Development Facilitation Team (DFT) – Review Comments

DRB Project No: PR-2022-007712 Date: 4/23/2025 Agenda Item: #2 Zone Atlas Page: C-11

Project Number: PR-2022-007712

Project Name: Tracts 1-A-1 thru 1-A-6, Block 2, Volcano Cliffs Subdivision, Unit 26

*Plat for
Tracts 1-A-1 thru 1-A-6, Block 2,
Volcano Cliffs Subdivision, Unit 26
Being Comprised of
Tract 1-A, Block 2, Volcano
Cliffs Subdivision, Unit 26
City of Albuquerque
Bernalillo County, New Mexico
May 2024*

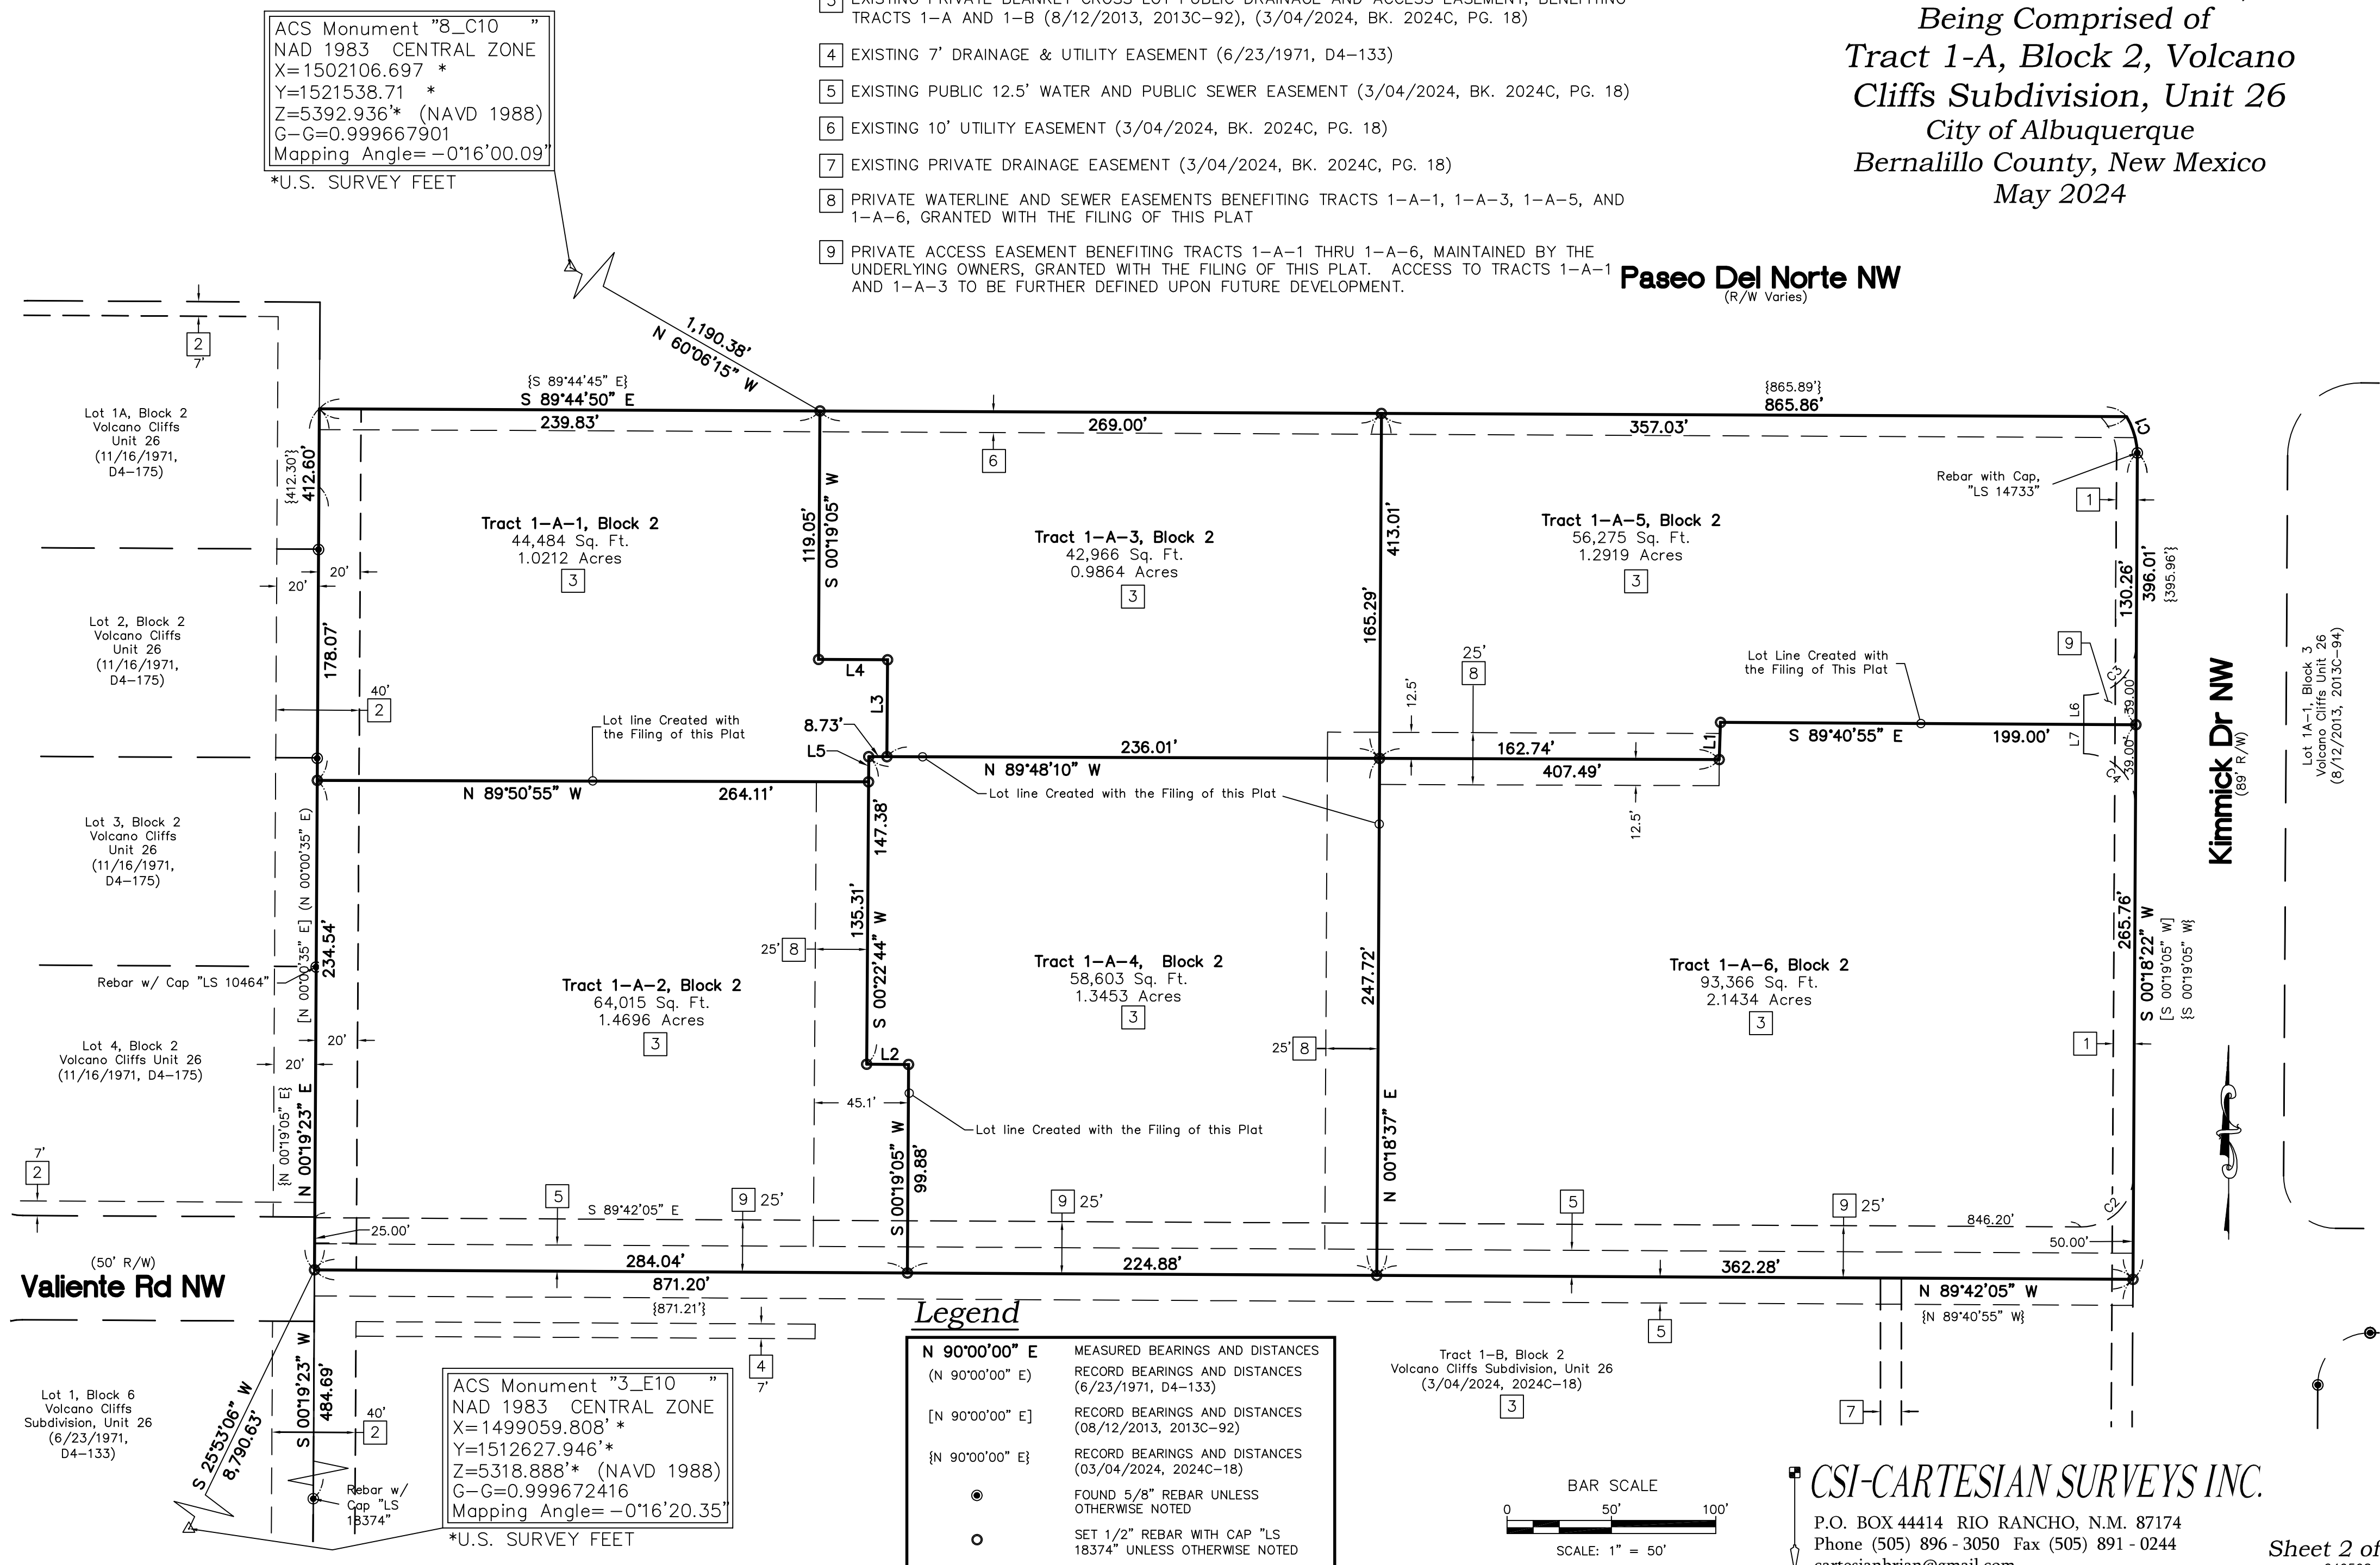
The construction of the entirety of Valiente Road along the southern boundary of the subject property will be tied to any future site development on Tracts 1-A-2, 1-A-4, or 1-A-6 as depicted on the Plat.
- The review criteria for a final plat are featured below. Staff request the applicant confirm that the review criteria are being met.

6-6(L)(3)(b) A Final Plat shall be approved if it includes all changes, conditions, and requirements contained in the Preliminary Plat approval.
- The application number (MJRFNL_PLT-2025-00001) must be added to the Plat.
- The DXF file must be approved by AGIS, and the approval email from AGIS must be submitted prior to final sign-off from Planning should the Plat be approved by the DHO.

- Per 6-6(L)(2)(d)(7) of the IDO, the date of the DHO approval shall be recorded on the Plat. Therefore, prior to final sign-off of the Plat, **the date of the DHO approval must be added to the Plat.**
 - After DHO approval and final sign off, **a recorded copy of the plat must be sent** to Angela Gomez at agomez@cabq.gov and to Jay Rodenbeck at jrodenbeck@cabq.gov.
 - Per 6-6(L)(2)(d) of the IDO, the applicant shall then record the final plat with the Bernalillo County Clerk as soon as possible, but in no case more than 30 consecutive days from the date of the last signature on the final plat, or the subdivision shall be voided.
-
